CITY OF ALBUQUERQUE

January 31, 2020

**RE: Dennis Chavez Community Center Ph 2 addition
715 Kathryn SE
Grading and Drainage Plan Stamp Date: 12/4/19
Hydrology File: L14D013**

Based on the submittal received on 1/23/20, the above-referenced Grading and Drainage Plan cannot be approved until the following are corrected:

A5 GRADING AND DRAINAGE PLAN
SCALE: 1"=10'

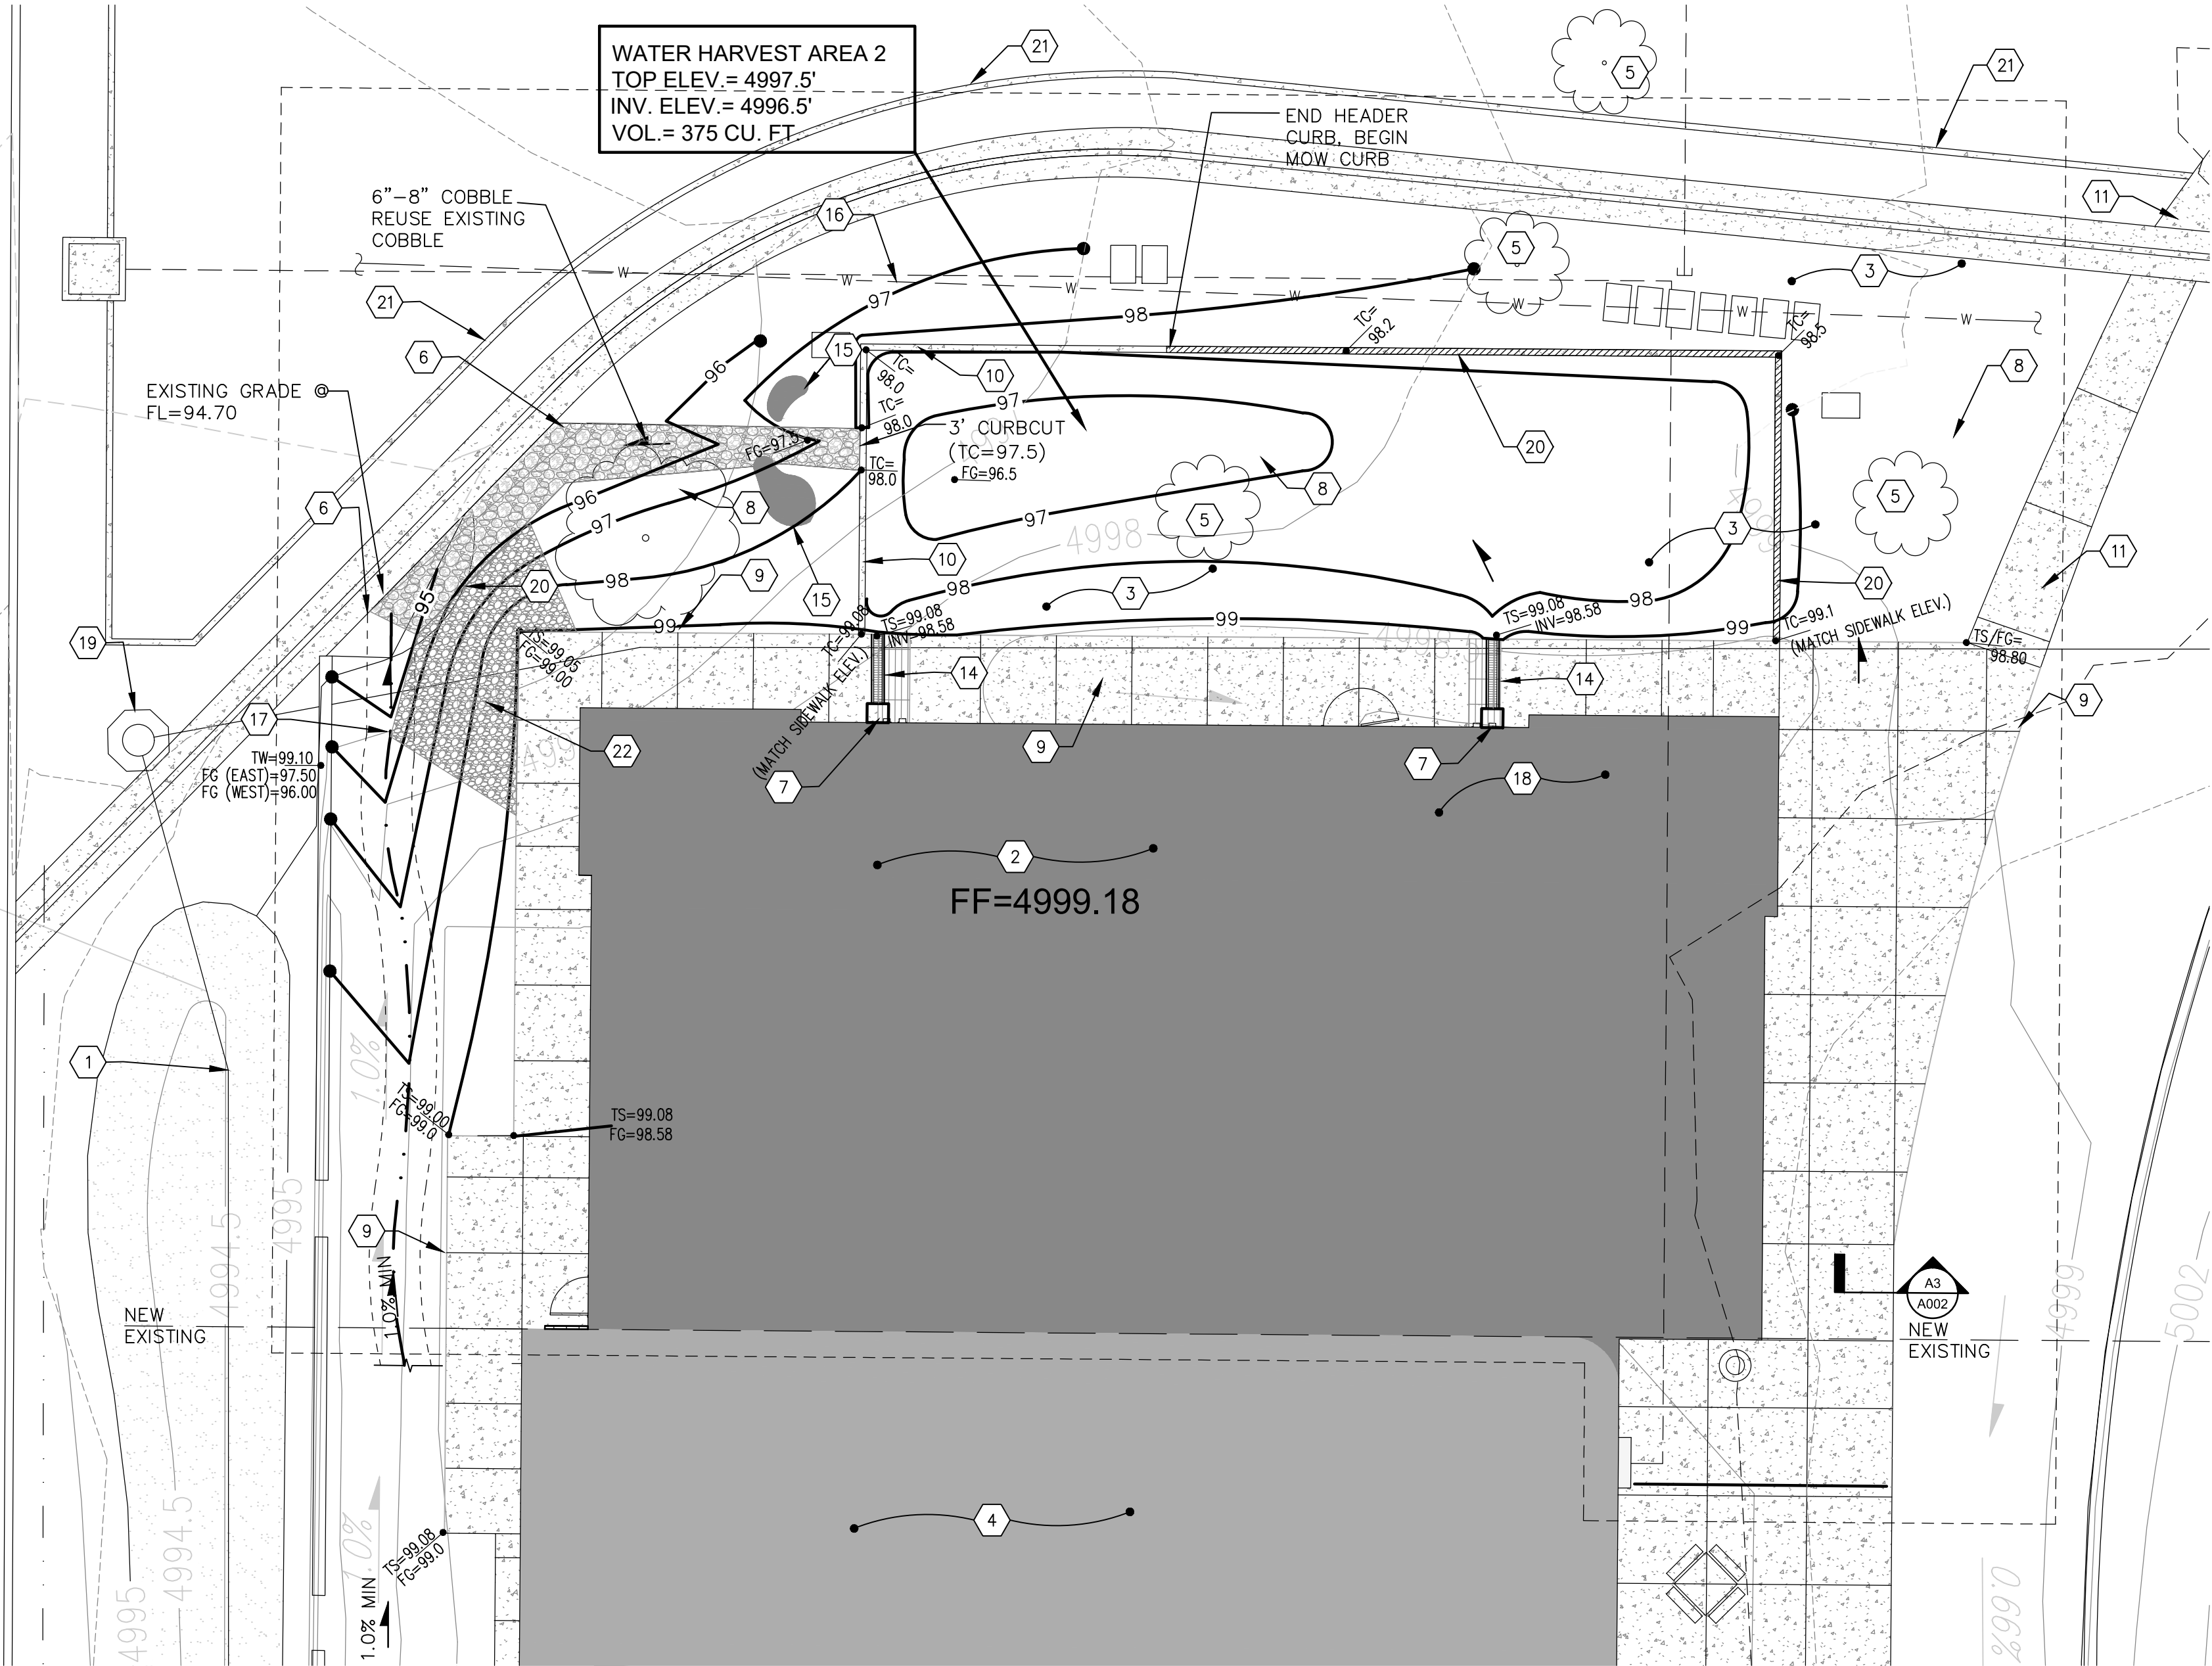
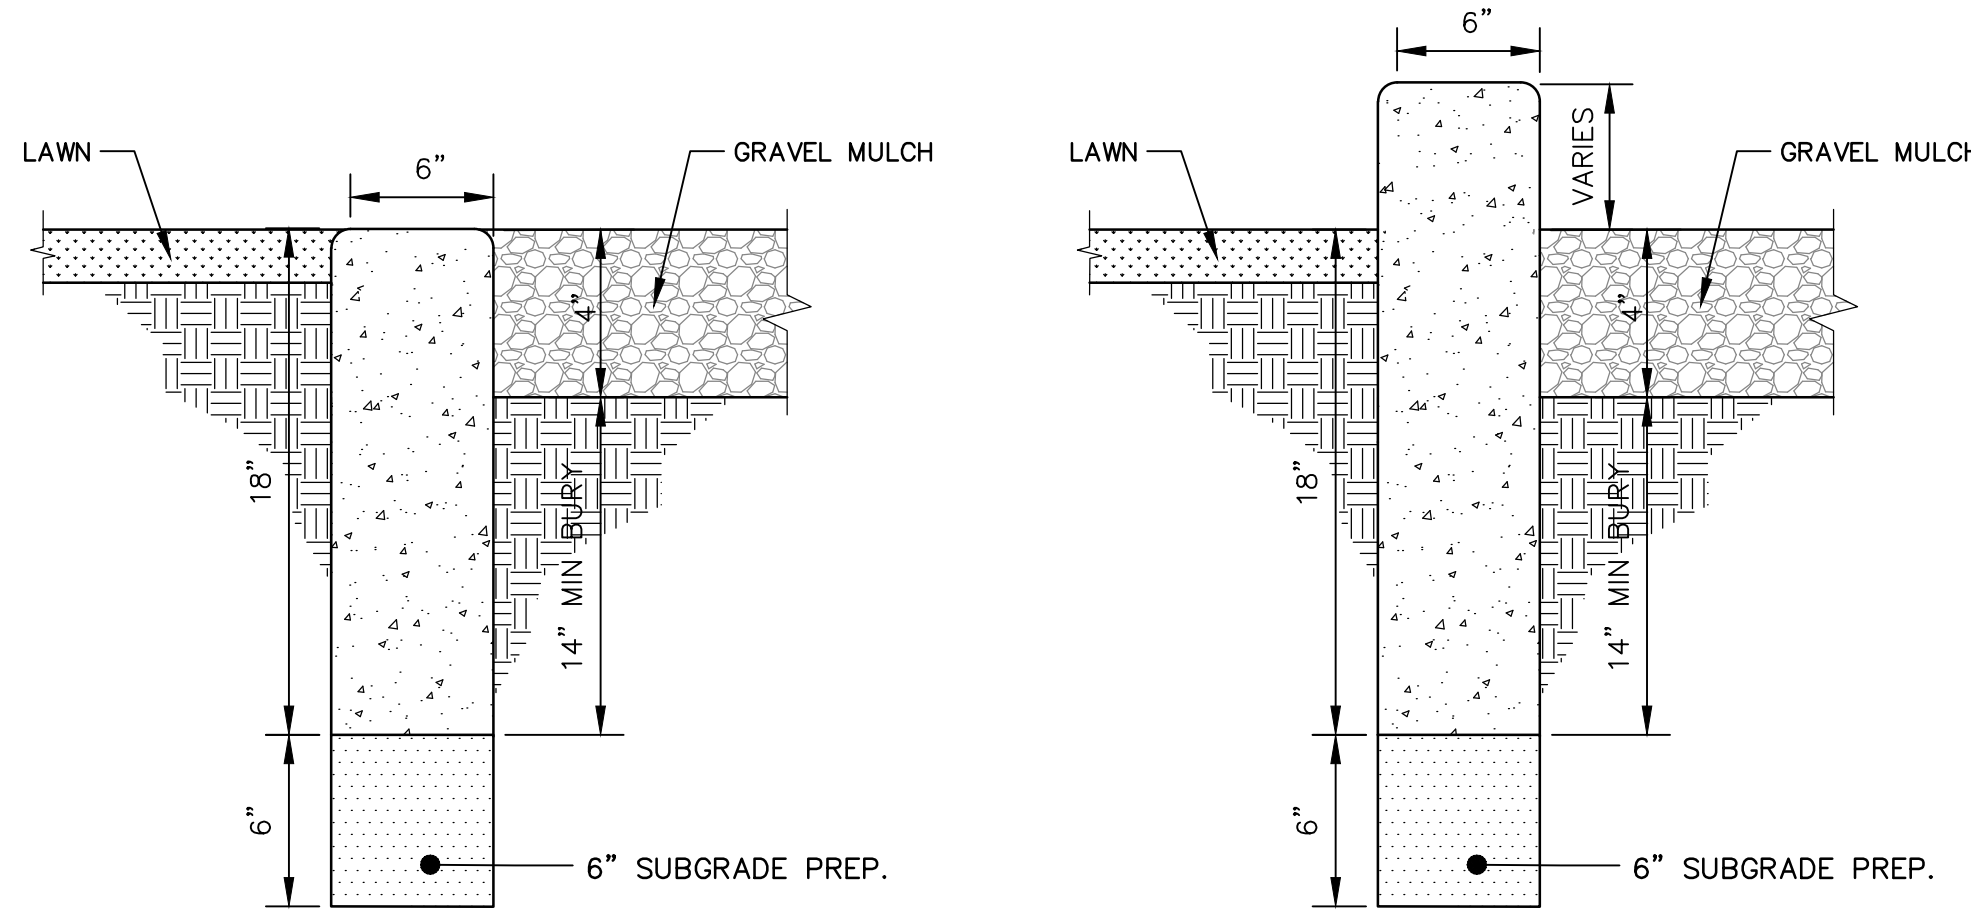
2. The existing contours need to be darkened to be visible and the hatching screened back on the addition. Show the work to demo the existing addition and build the new larger one. It may make more sense to break the existing condition and proposed addition into two viewports.

3. How will the existing stormwater quality pond be relocated? Ensure it will still capture its required stormwater quality volume (SWQV), plus the additional SWQV created by this project.

4. Please provide the SWQV calculations for each basin draining to each pond, including to the existing west pond and the relocated existing pond. The stormwater quality ponds need to be sized for the areas draining to them. The pond on the west side of the building can probably be upsized to capture any of the bypass volume.
